WELWYN HATFIELD COUNCIL  
PLANNING CONTROL COMMITTEE – 28 AUGUST 2008  
REPORT OF THE CHIEF PLANNING AND ENVIRONMENTAL HEALTH OFFICER

S6/2008/0690/FP

ST AUDREY'S CAR PARK, CHURCH LANE, HATFIELD, AL9 5NB

IMPROVED ENTRANCE TO HATFIELD PARK FOR COACHES AND HGV'S,  
WIDENING THE ACCESS FROM CHURCH LANE, FORMATION OF COACH  
PARKING AREA, CIRCULATION TRACKWAY AND ALL ANCILLARY WORKS

CLIENT:	THE CASPIAN CENTRAL ENTRIES
JOB:	ST AUDREY'S ENTRANCE
DATE:	MAR 2008
SCALE:	1:500
DRAWING TITLE:	PROPOSED SITE PLAN
DRAWING NUMBER:	757-002 E

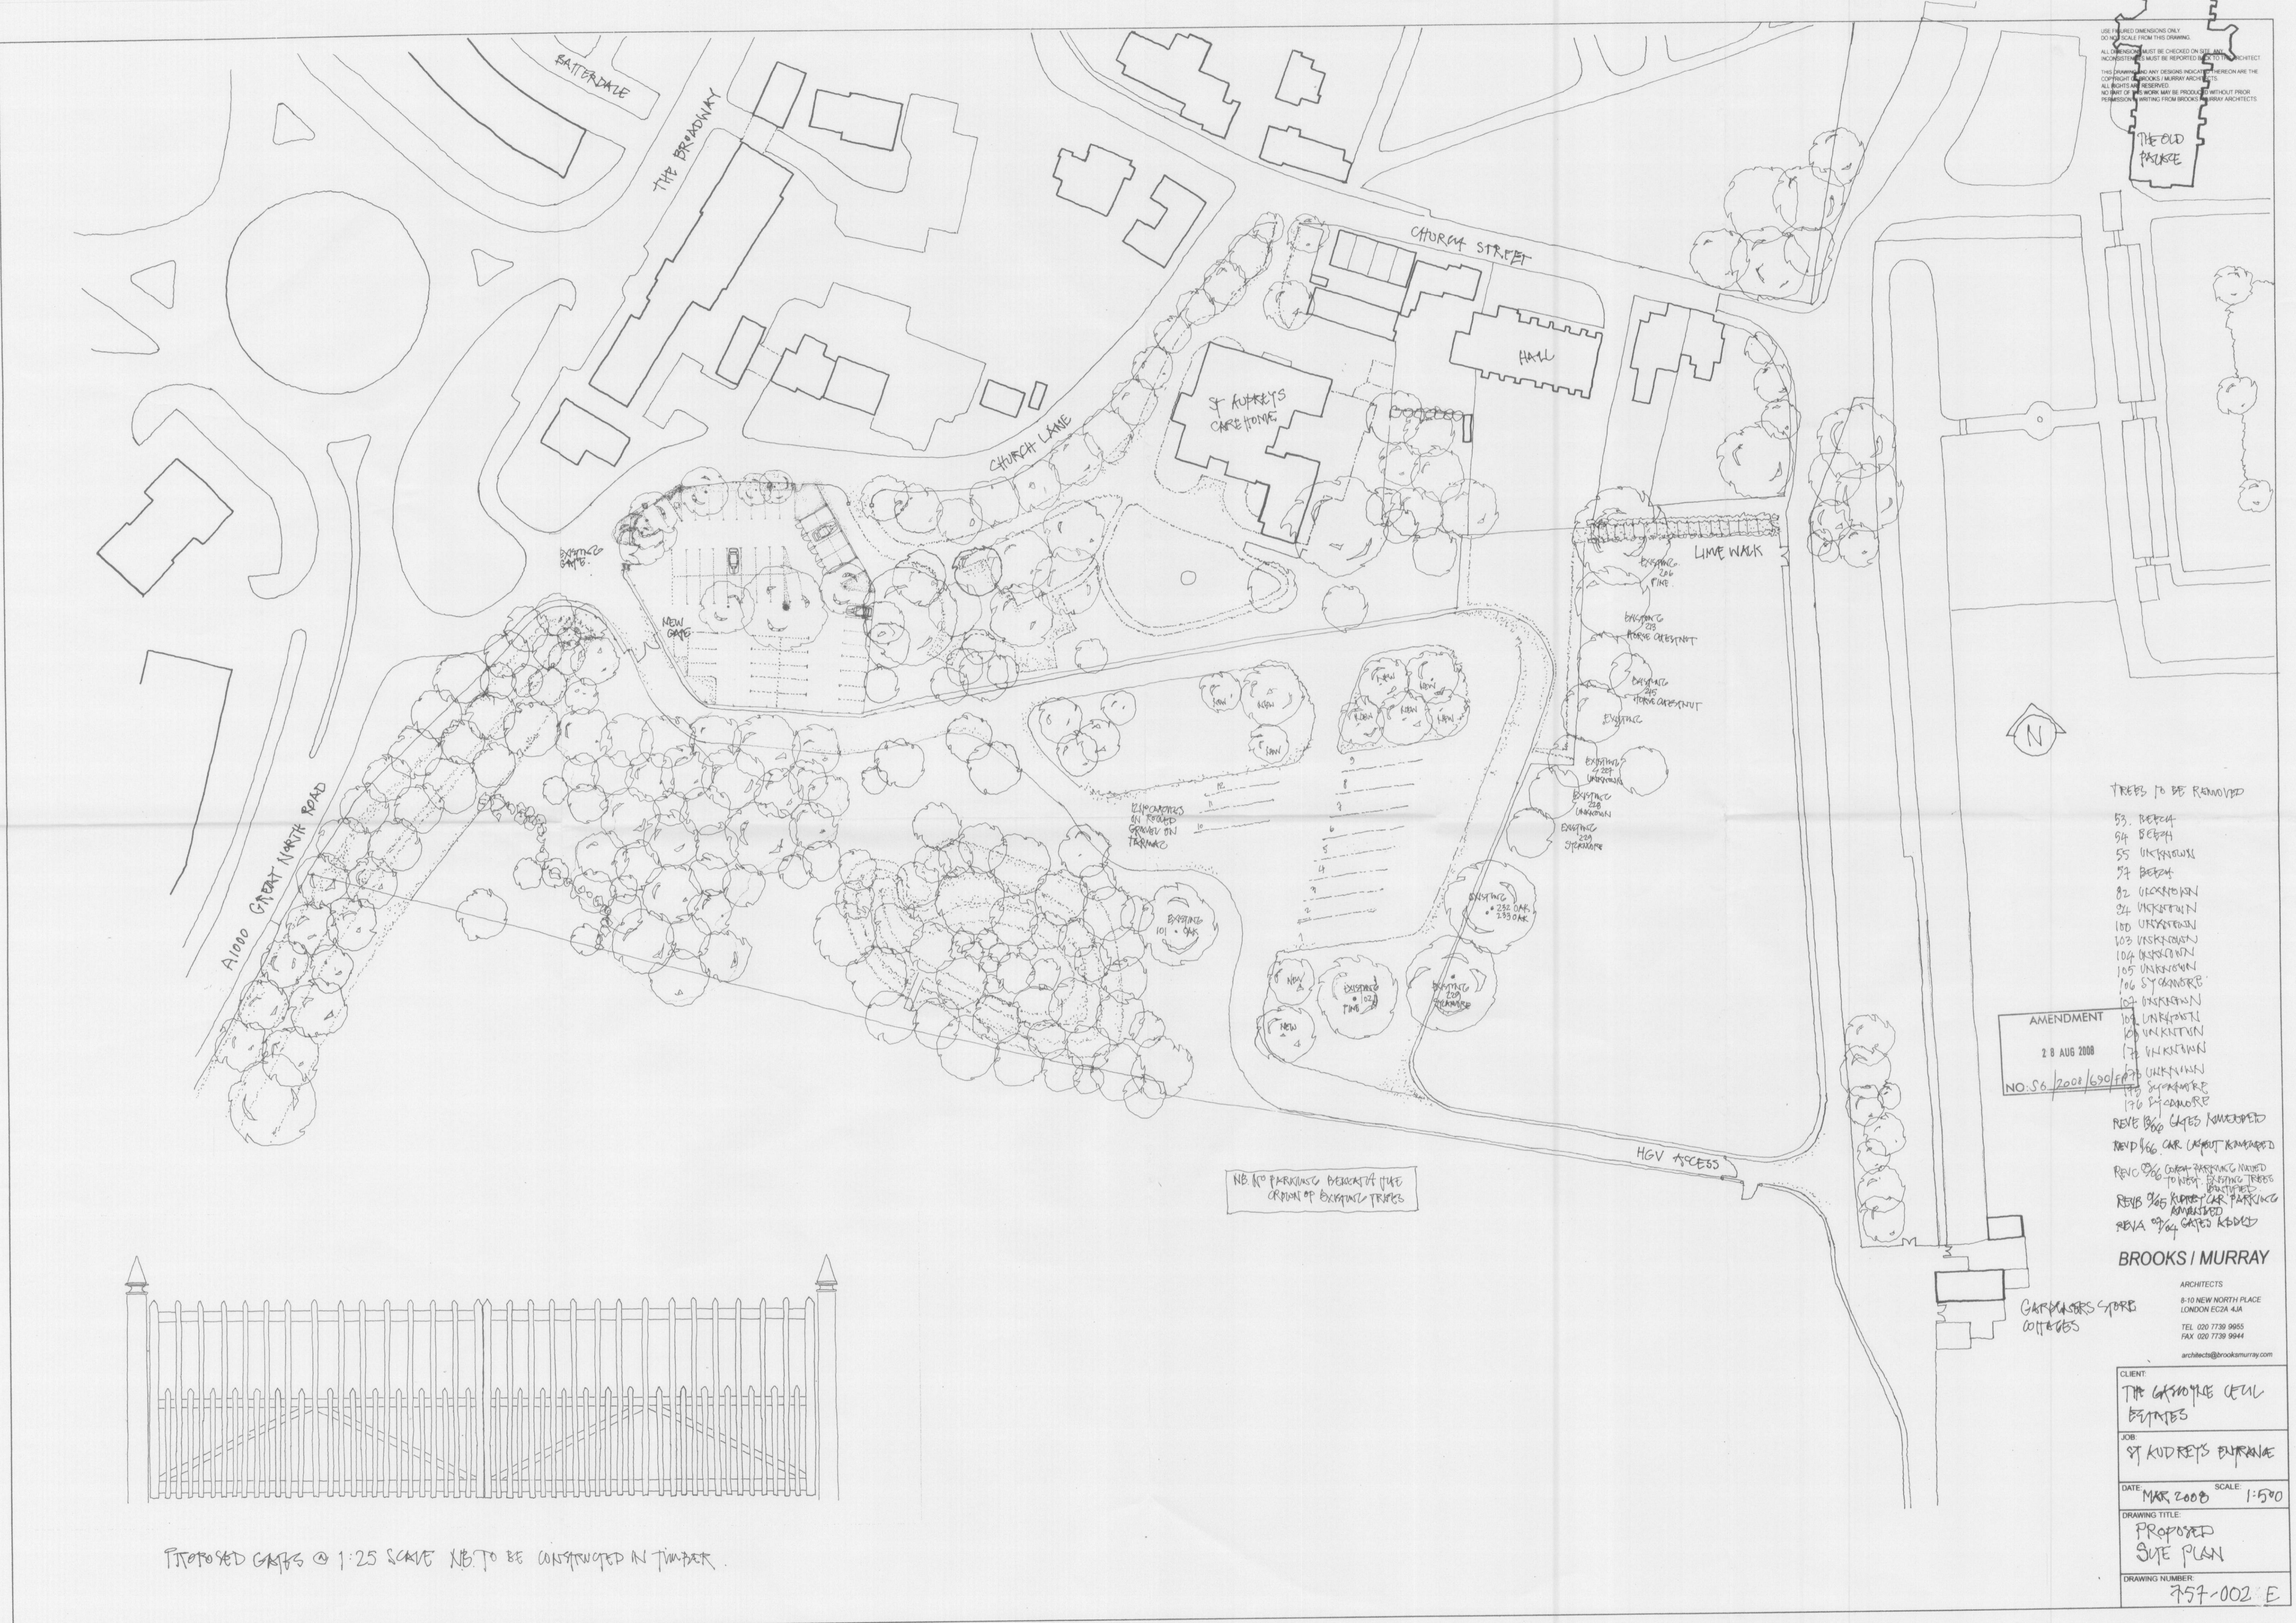
- 5.1 **Hertfordshire County Council Highways** – have responded on the 26<sup>th</sup> May and further on the 17<sup>th</sup> June.
- 5.2 Their initial comments raised concerns regarding the location of the gate which would need to be sited 20 metres from the highway boundary to prevent

vehicles waiting on the highway. There were concerns that coaches would not be able to swing into the new access road and that if another vehicle was exiting at the same time that this would lead to a highway hazard. Further details were requested, as well as a number of conditions suggested regarding signage on the highway.

- 5.4 **Landscaping Section** – Had strong objections to the original layout of the scheme and considered that it would have a significant detrimental impact upon the health of a number of trees within the surrounding area.

- 5.5 The new layout has been negotiated, which is more sympathetic to the trees on the site, with hard standings a reasonable distance from the trees and no parking beneath the crowns of existing trees.

5. Prior to the commencement of the development hereby permitted, details of the materials proposed for the gated entrance shall be submitted to the Local Planning Authority for approval in writing. The approved details shall subsequently be implemented in accordance with the approved details. For clarification the gate is approved at a scale of

1:25 as shown on the plan submitted 17<sup>th</sup> June 2008 and not as shown on drawing 757-002D.

18. Between the hours of 2130 and midnight coaches shall be parked in spaces labelled 1 – 4 as shown on drawing number 757-002D dated 17 June 2008 and in no other part of the site.
